This site plan needs to show the following items:

John Olson
Please identify the land disturbance that is on the north eastern corner. Per ECM appendix I, land disturbance of one acres or greater, or 500 cubic yards, triggers water quality treatment on site.

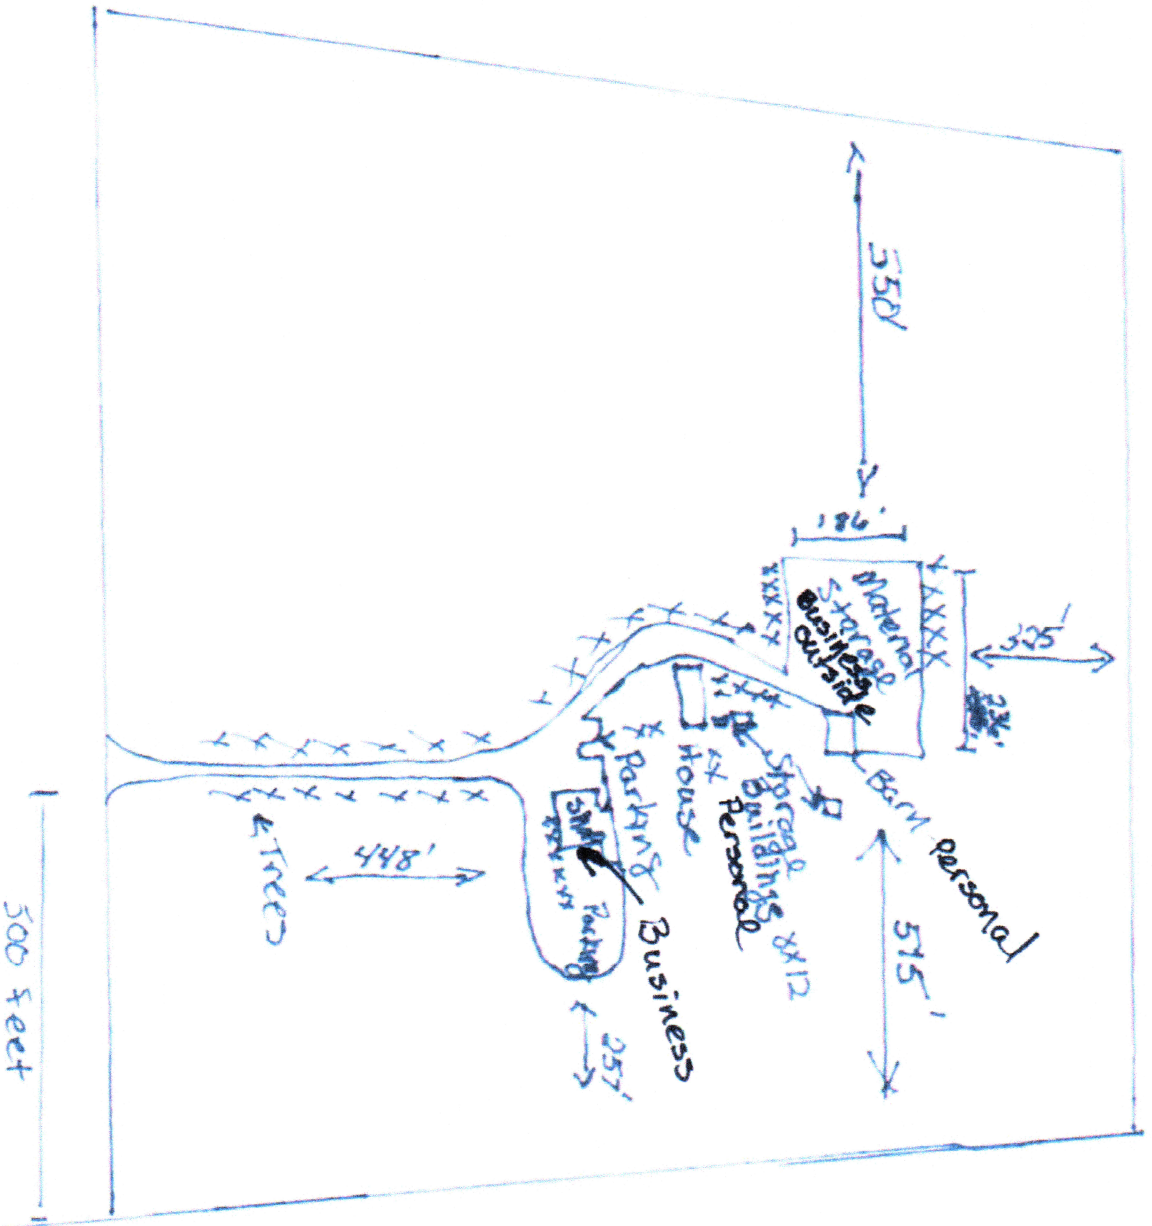
- 1) Owner name, contact telephone number, and email for responsible party
 - 2) Property tax schedule number
 - 3) Lot area coverage calculation
 - 4) Lot area coverage calculation

- 5) Current zoning of the property
 - 6) Date, north arrow, and a graphic scale
 - 7) Vicinity map showing the property in relation to the surrounding area

- 8) Location of the property line, right-of-way, and all existing and proposed easements
 - 9) The outlines of all buildings showing their proposed uses, setbacks, dimensions, floor area, number of stories, height and points of access in relation to the lot configuration

- 10) Location and dimensions of all sidewalks, fences, walls, or berms
 - 11) The outlines of all buildings showing their proposed uses, setbacks, dimensions, floor area, number of stories, height and points of access in relation to the lot configuration

- 12) Location and dimensions of all existing and proposed signage on site
 - 13) Traffic circulation on site including all points of ingress/egress into the property

- 14) The layout and location of all off-street parking, loading and other vehicular use areas
 - 15) Location of all ADA spaces, ramps and signs, including ADA pathways

- 16) Location, height and intensity of all outdoor illumination
 - 17) Location of existing and proposed water and wastewater infrastructure, including well and septic location if applicable

- 18) Location of all no-build areas, floodplain, drainage facilities
 - 19) Location and screening of all garbage receptacles
- Standard details of parking (compact, ADA, standard), ADA ramps, driveways, dumpsters and signs

- 20) Location of all existing and proposed utility lines and associated infrastructure
 - 21) A data table that includes the following:
 - a. Existing/Proposed land use and zoning

- b. Total area of land to be disturbed
 - c. Total gross building square footage of all existing and proposed buildings
 - d. Parking computations (required, provided, etc.) to include ADA parking
